**Consultation Response from KC,
Highways Development Management**

2021/93565 Land Adjacent, Hazeldene House, Stoney Bank Lane, Thongsbridge, Holmfirth, HD9 7LZ

Removal of condition 5 (Construction Method Statement) on previous permission 2020/91213 for erection of detached dwelling and formation of new access (modified proposal)

**Date Responded:
07/12/2021**

Description: **PROPOSED CONSTRUCTION MANAGEMENT PLAN**

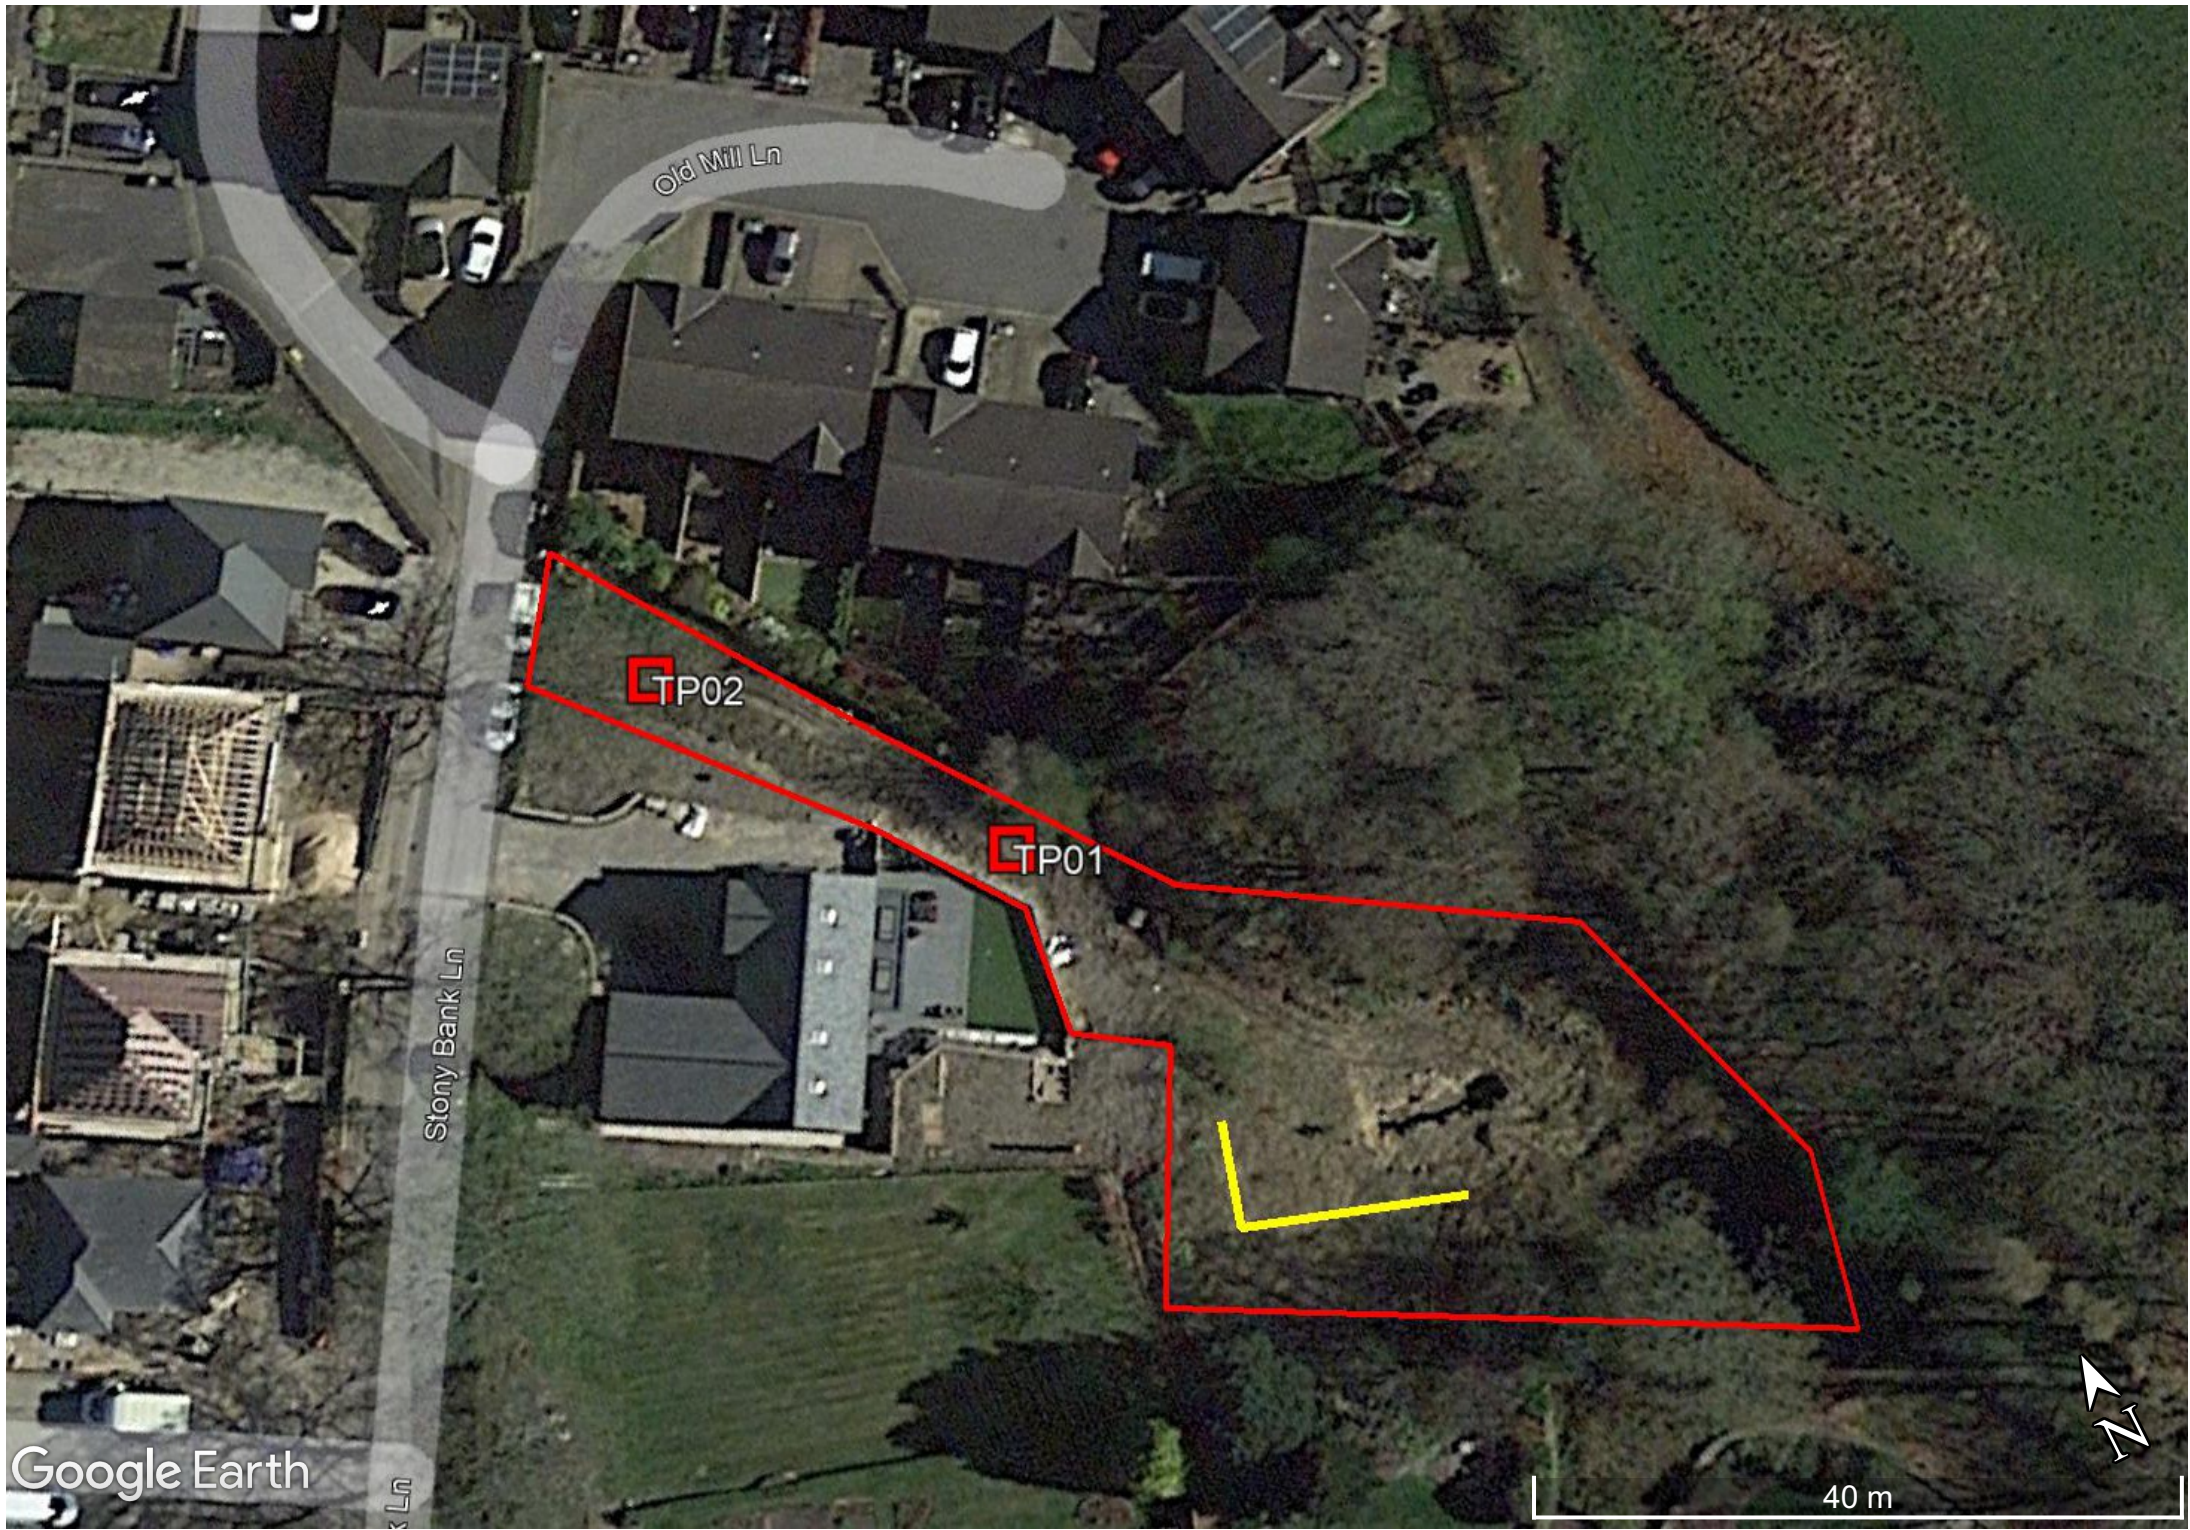
The applicant has submitted a construction management dwg/plan (ref L(100)10) dated Sept 21, contained in the submissions is the required information to satisfy condition 5 to be removed subject to the applicant adhering to the requirements contained within said submissions.

HDM consider the information provided acceptable, condition 5 can be discharged as required.
